Morris Goding
Access Consulting

Billbergia

Eden Street, Arncliffe

Access Review – Final v3

1 UPPER GROUND
1:250

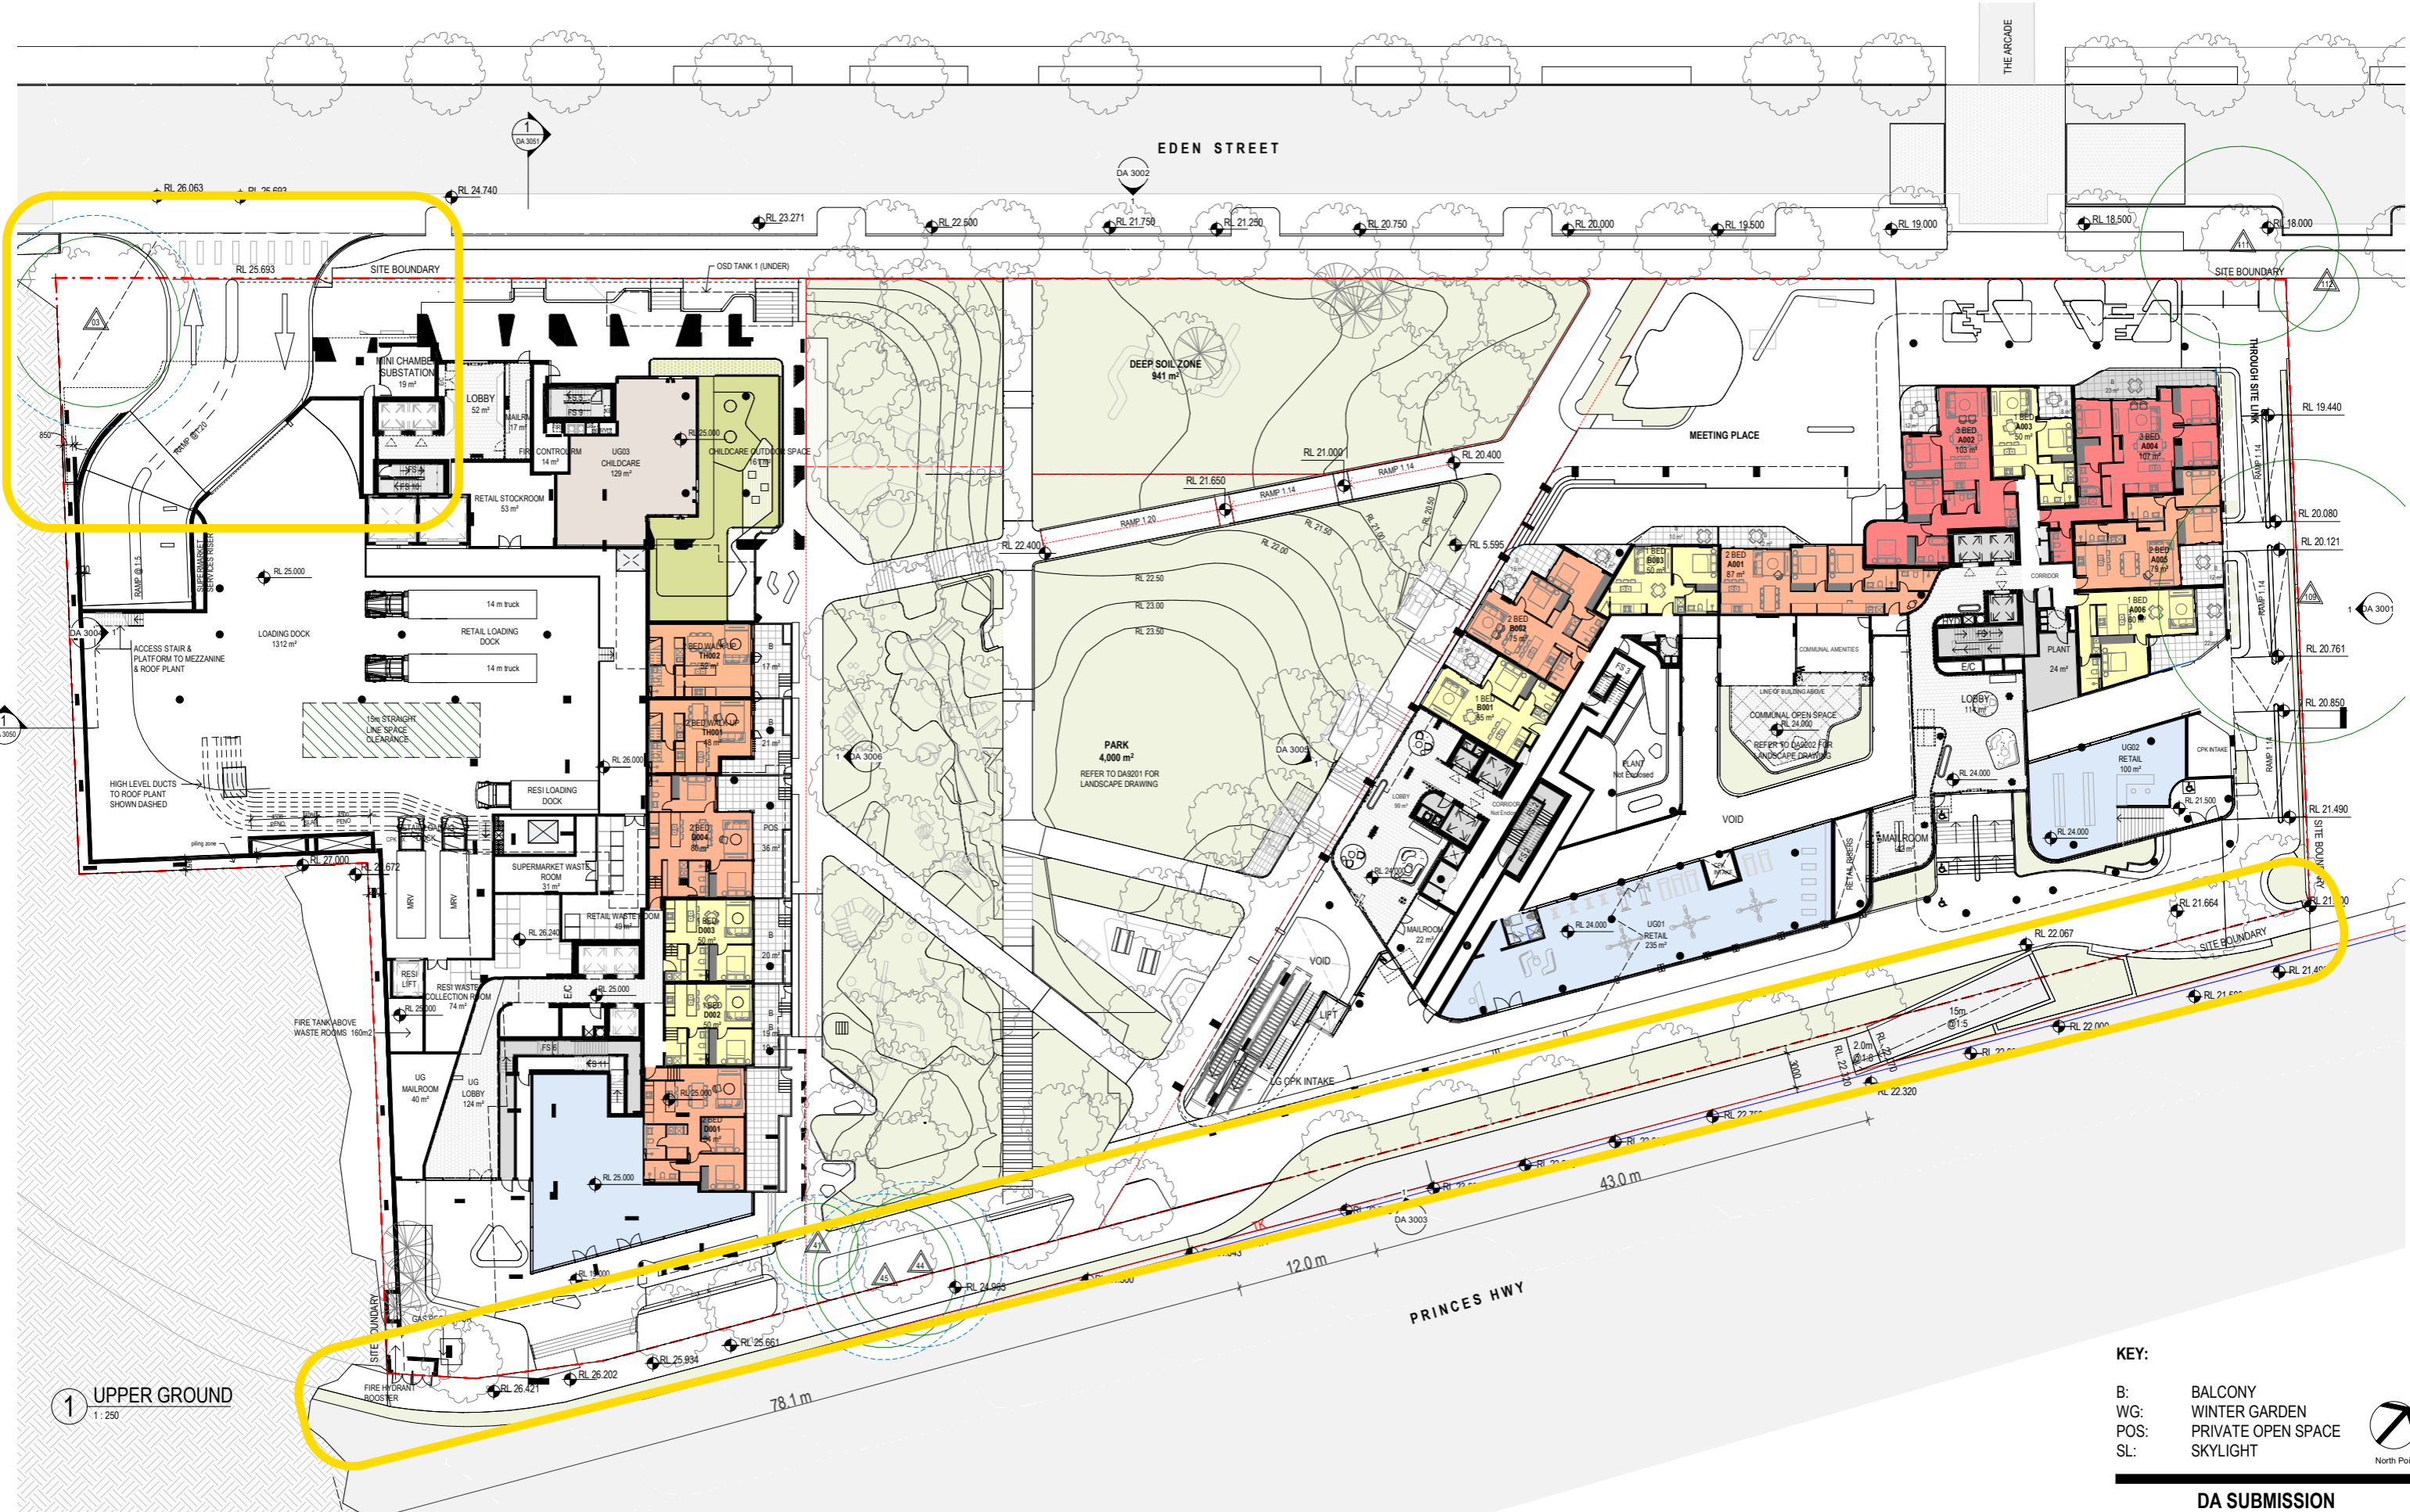
However, Eden Street northwest building is access via stair only, an adjacent accessible path will be required to achieve compliance in accordance with the DDA Premises Standards.

Currently, majority of buildings entrance points have an accessible entrance compliant with AS1428.1 and the DDA Premises Standards. However, amendments are required to be made to ensure an accessible pathway and entrance to retail tenancies and Tower A in accordance with AS1428.1 and the DDA Premises Standards, although, space is ample to amend and readily achieve compliance at later design stages as per AS1428.1 and the DDA Premises Standards.
